### Re: Coffs Harbour bypass; SSI\_7666 Review of Operational Noise Assessment

This submission is purely about operational traffic noise as presented in the EIS, in particular about noise in the night period and potential impacts on surrounding residential receivers.

Appendix A: Operational Noise Table Inconsistency

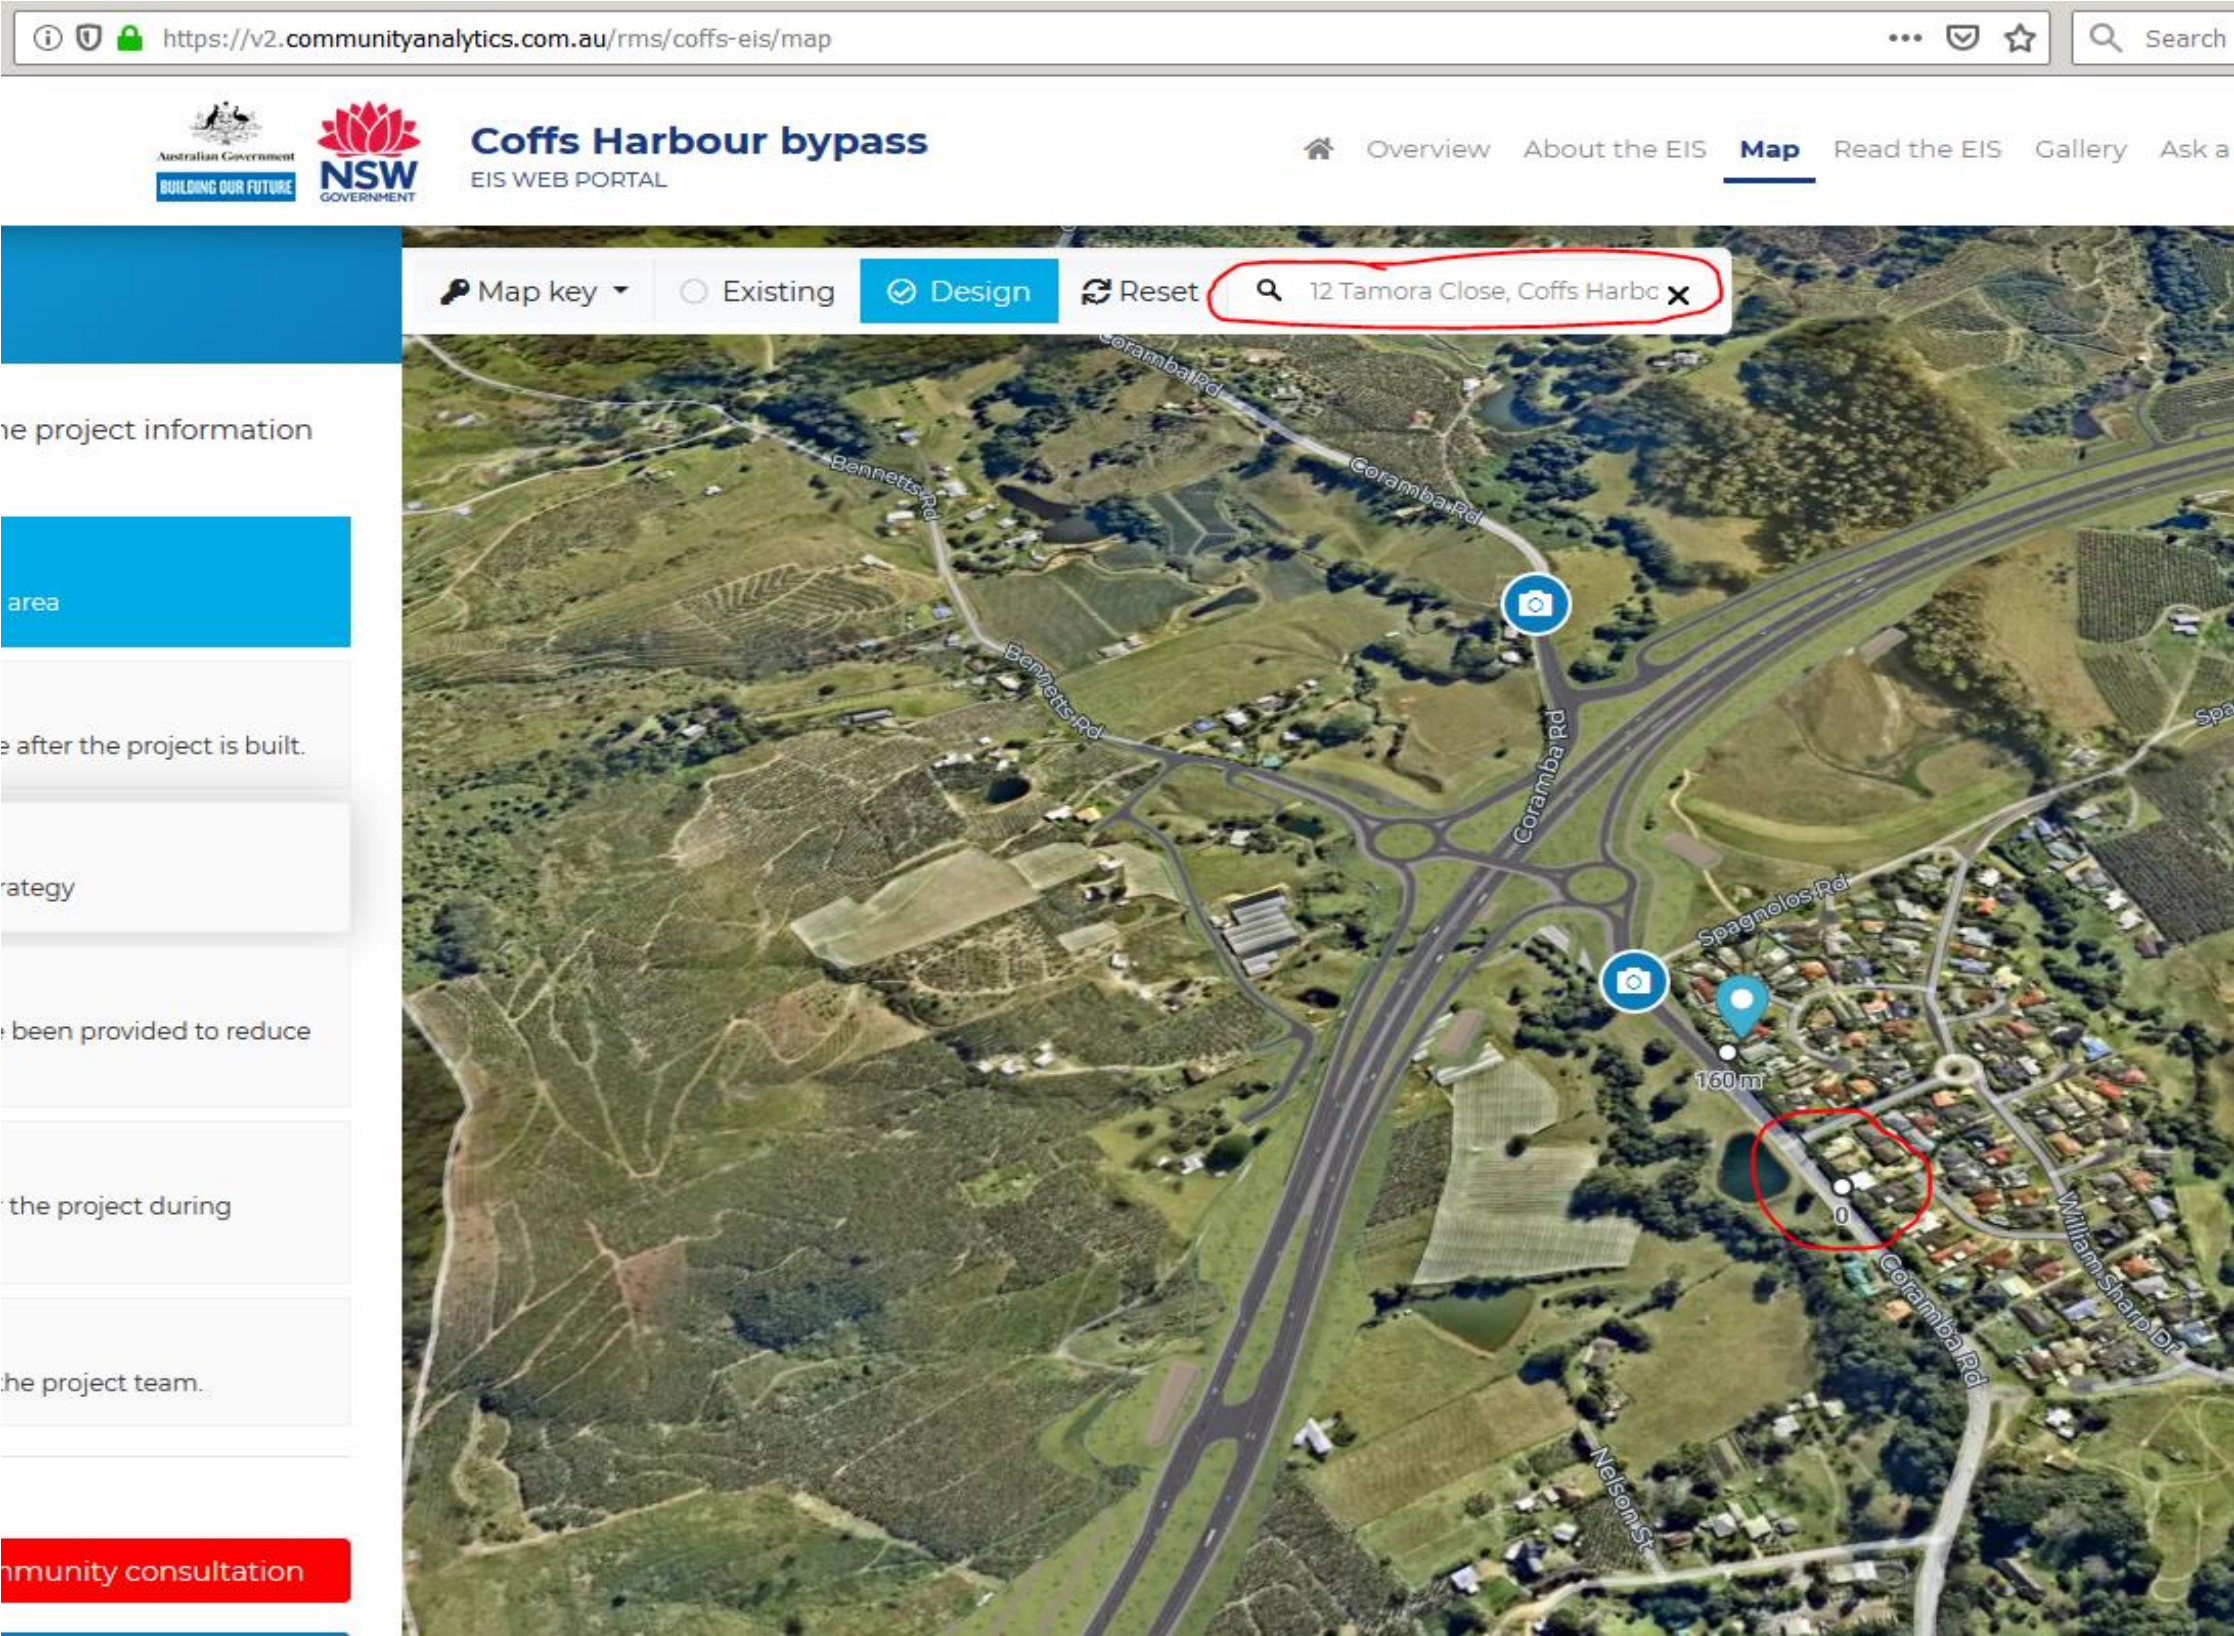
- See Attachment A for details.
- A façade on the southern side of **12 Tamara Close**, a residence backing onto Coramba Road. Measured in the EIS (Logger 4) in the field right next to the road at 52 dBA and assigned an Unmitigated Night No Build figure of 52 dBA at the southern façade of the residence. Given the growth in traffic to 2024 and the extra distance of the façade from the main source of the noise this appears reasonable.

- What cannot be correct is that this façade is modelled at baseline **52 dBA** whereas the same position 160 metres further down the road at **15 Safrano Place** is modelled at **60 and 64 dBA**. A difference of around 12 dB!

- What also cannot be true is that the same façade at 12 Tamara Close, which is 160 metres closer to the new Bypass and interchange, will have a final mitigated noise level of **52 dBA** when 15 Safrano is modelled to finish up at **61 and 65 dBA**. Again, a difference of around 12 dB!

T4A: Ambient Measurements - NCA13 Adjacent to Coramba interchange

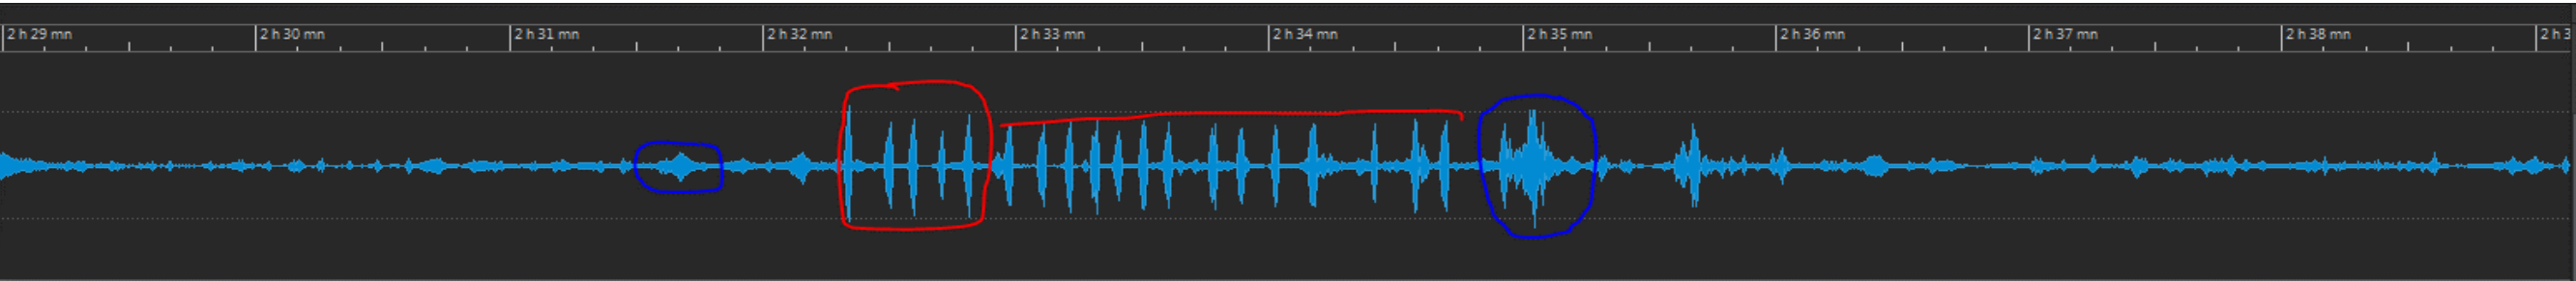
- A façade on the southern side of the residence backing onto Coramba Road. Measured 18 and 20 metres from Coramba Road:
- Focus on the highlighted cells, **the 5 – 7 am period is characterised by a significant ramp up in local traffic, plus bird noise.**
  - Leq readings for **10 pm until 5 am of 45 dBA** and **5 - 7 am of 55.6. Shows the skewed nature of the traffic on Coramba Road.**
  - A jump of > 10 dB(A) between the first 7 hours and the last 2.
- In this instance, properties right on Coramba Road, the skewed nature of the early morning period (in this case dominated by local traffic) should be taken out because it skews the whole night time period. It will be used to justify bringing a higher target for the Highway Night Truck profile which will impact more dramatically the first 7 hours. This is inequitable.

From Appendix B in my attachment: A typical 10 minute period in the 5 – 7 am time period

The Leq's are 56.2 for each 5 minute period. Traffic events are circled in blue, birds in red, and often both, red and blue at 2 hours 29 min.

T5: Ambient Measurements - Korora

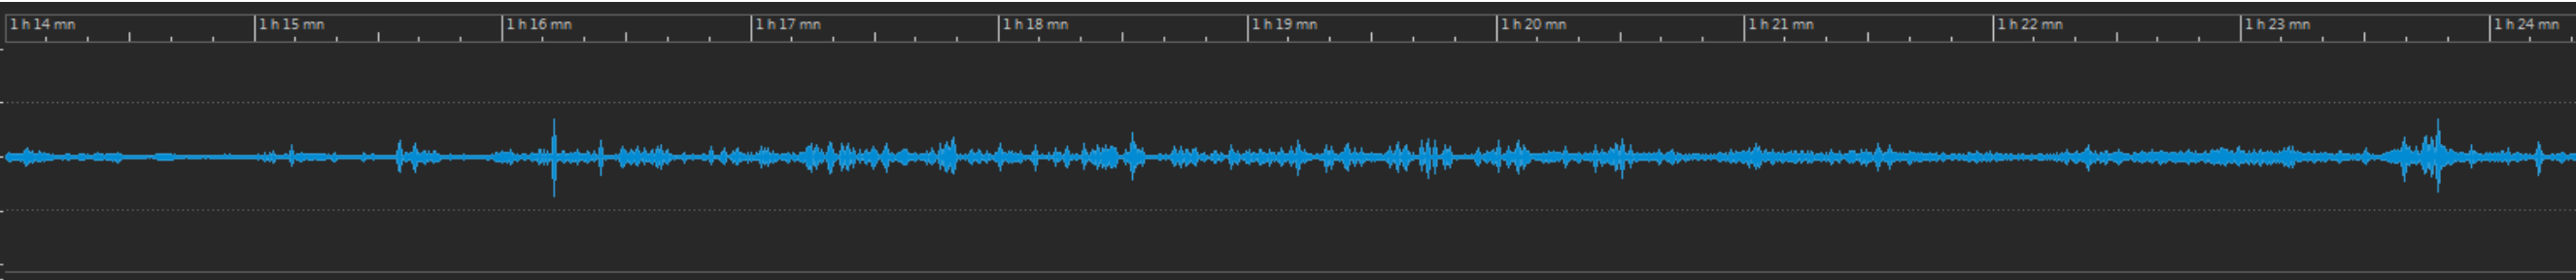
- A façade on the western side of a residence **410 metres from the existing highway (speed limit 80 km/h)**. Note also that this property is elevated from the highway and the highway at this point travels in a wide arc around the residence.
- Measured Leq readings for 10 pm until 5 am of **41.1 dBA** versus **50.1 dBA** in the 5-7 am time period, giving **45.1 dBA over the 9 hours**. A jump of 10 dBA
- However the 5-7 am time period is dominated by bird noise to the extent that the highway noise is just a hum in the background.

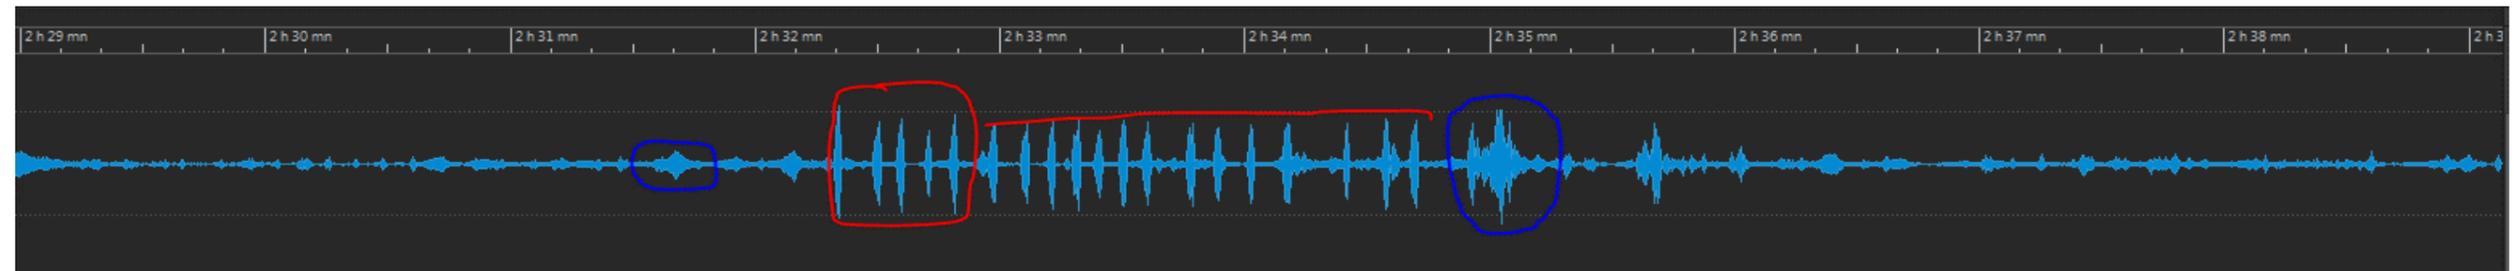
- A façade on the western side of the residence 80 metres from Coramba Road.
- Focus on the highlighted cells. This time **the 5 – 7 am period is dominated by bird noise.**

- Leq readings for **10 pm until 5 am of 36.8 dBA** and **5 - 7 am of 49.1.**
  - A jump of > 12 dB(A) between the first 7 hours and the last 2.
- In this instance, properties 80 metres or more from Coramba Road, the skewed nature of the early morning period (in this case dominated by bird noise) should be taken out because it skews the whole night time period. It will be used to justify bringing a higher target for the Highway Night Truck profile which will impact more dramatically the first 7 hours. This is inequitable as summarised in Finding 4.

Appendix B in my attachment: A typical 10 minute period in the 5 – 7 am time period

The Leq's are 54.5 & 53.5 for the 5 minute periods. Traffic events are circled in blue, birds in red. This is mostly bird noise.
